Submissions Report

Punchbowl, Affordable Housing, State Significant Development

150 The Boulevard and 34 Dudley Street, Punchbowl

SSD-83256463

1 Visual Privacy - Communal Open Space to No. 149 The Boulevard
1:50

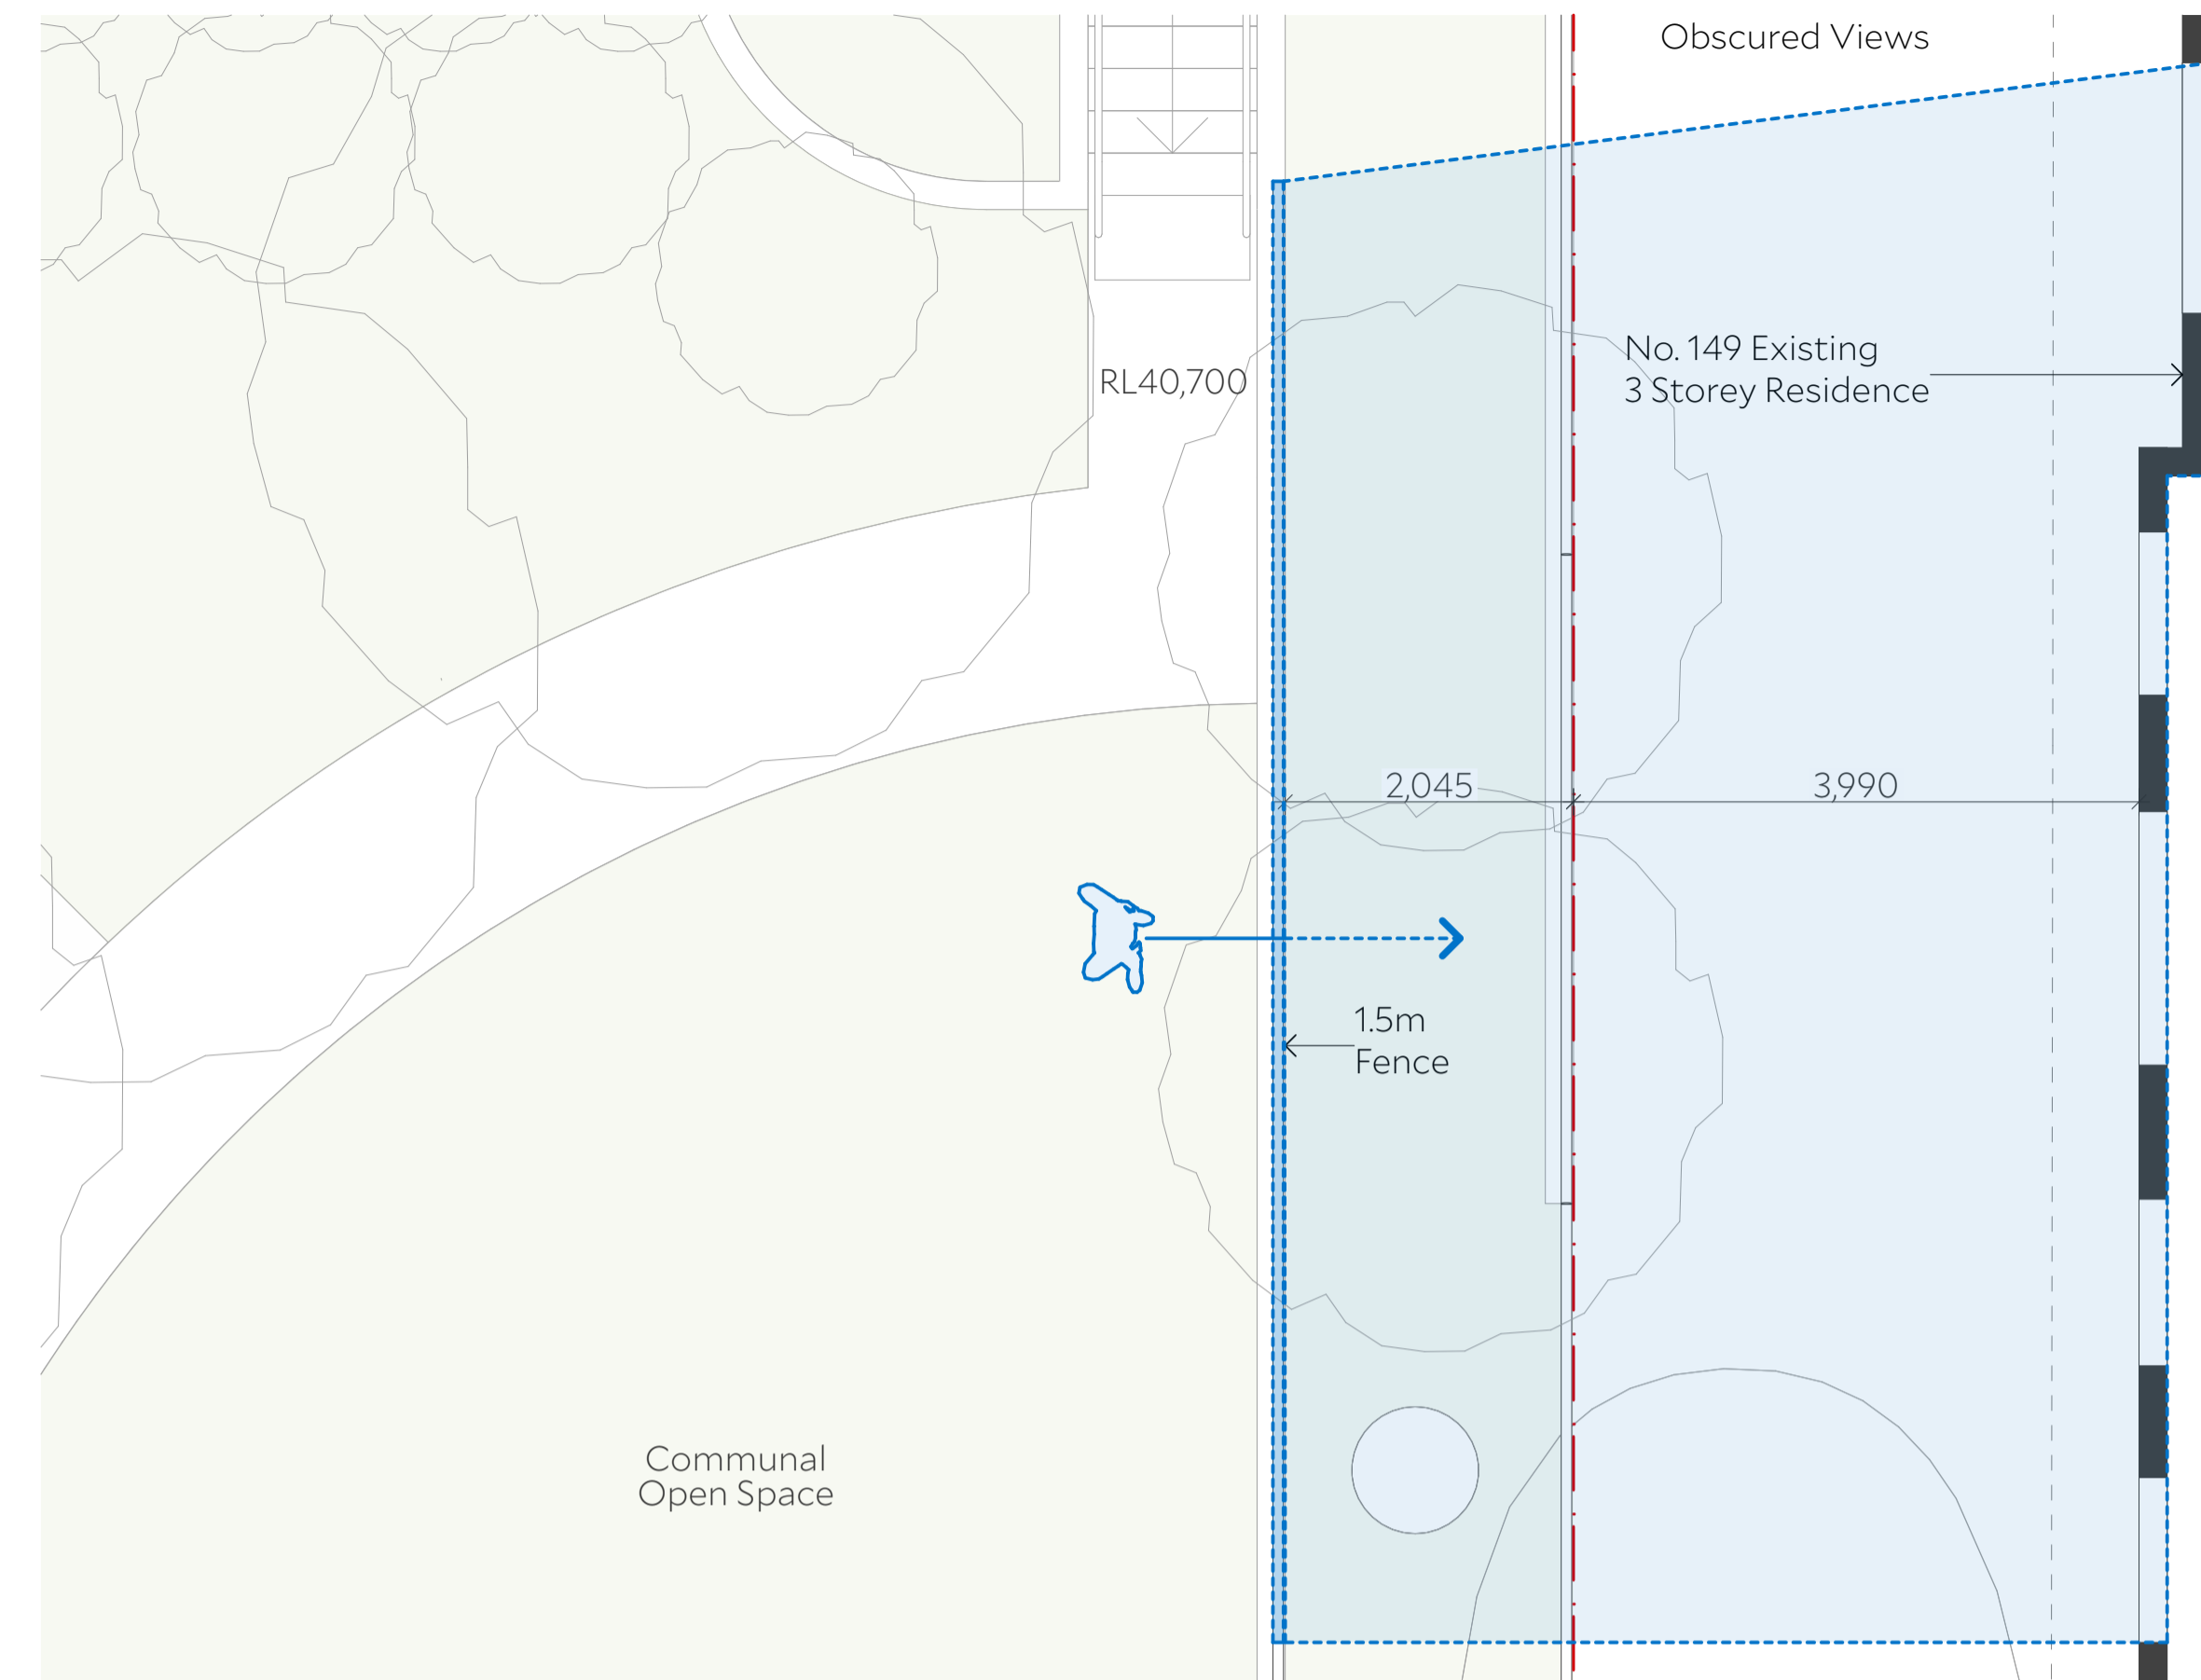
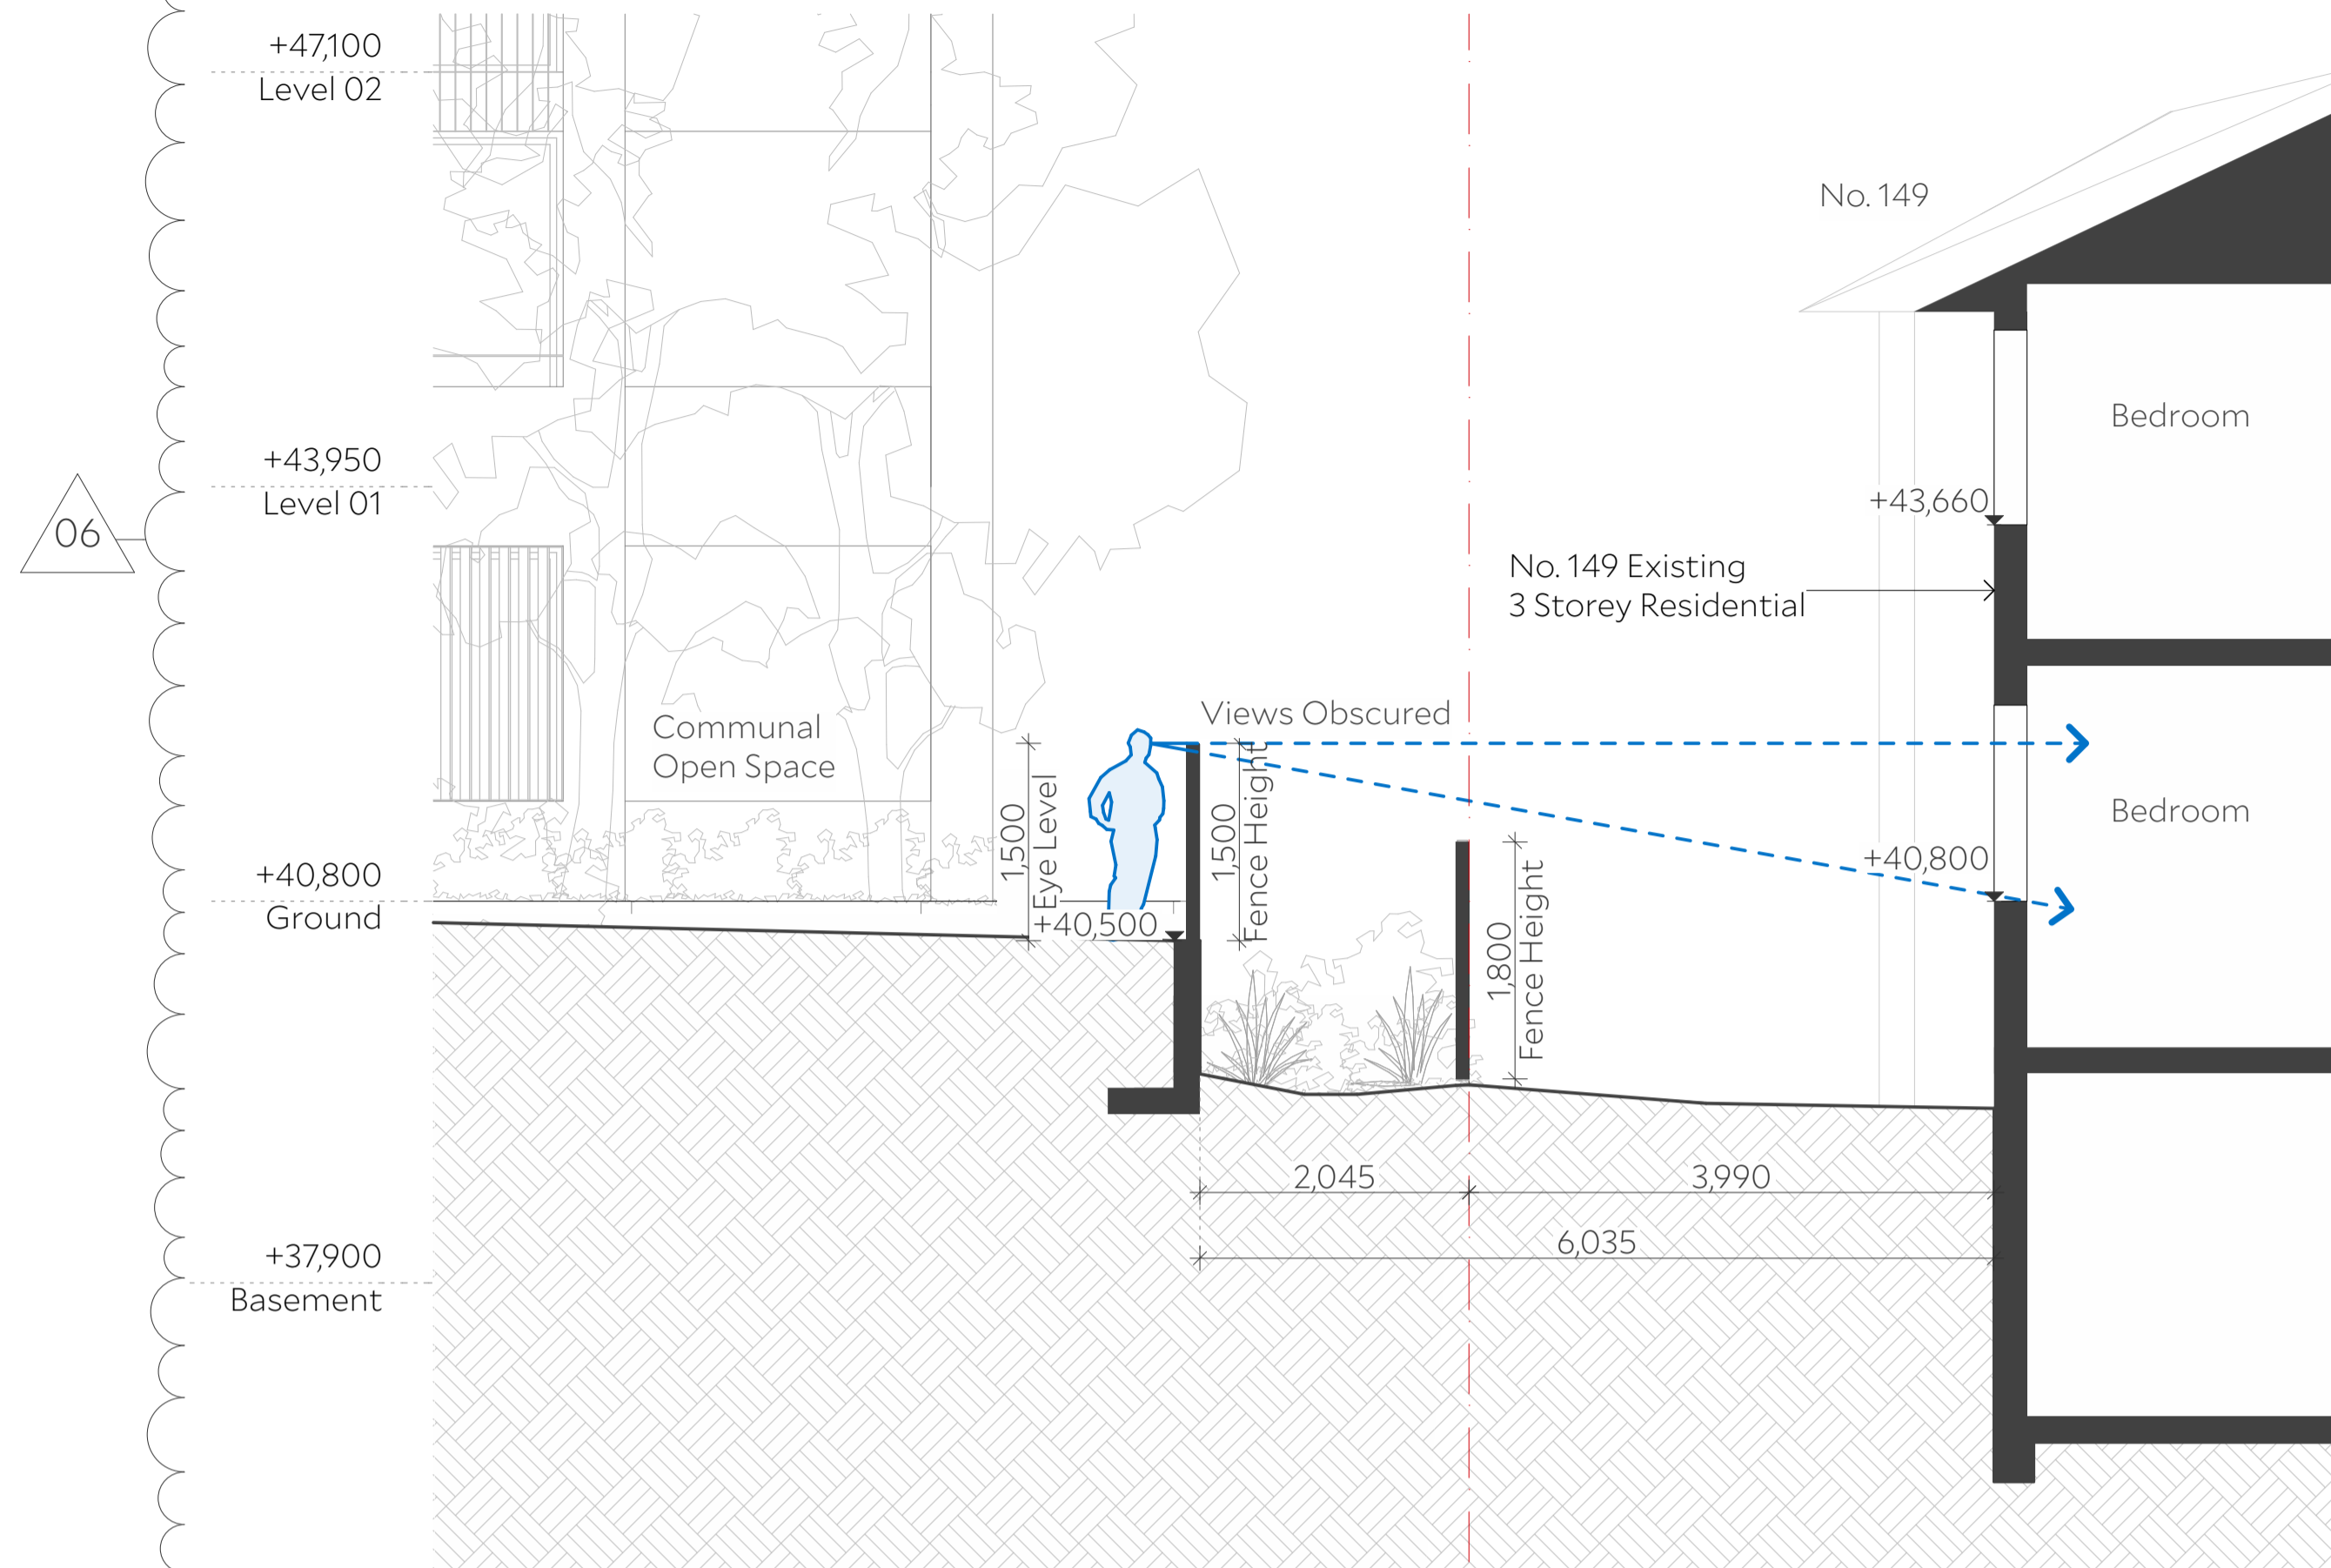
3. Amenity impacts to surrounding properties		
3.1	The finished ground level of the communal open space (RL 40.50-40.70 AHO) may enable overlooking to habitable room windows at No. 149 The Boulevard, which have sill heights of RL 40.80 and RL 41.14 AHO (as per Survey Plan). Mitigation measures must be included to address this potential overlooking. The Department does not support landscaping as a sole mitigation measure for visual privacy.	Additional screening (1.5m) has been integrated into the design of the communal open space as a mitigation measure to minimise the potential for overlooking from the communal open space into habitable rooms of the neighbouring property at 149 The Boulevard. The diagram below shows the proposed screening to minimise overlooking to 149 The Boulevard.  Refer to the Sightline Analysis in the updated Architectural Plans at Appendix B, and updated Landscape Plans at Appendix C for further detail.
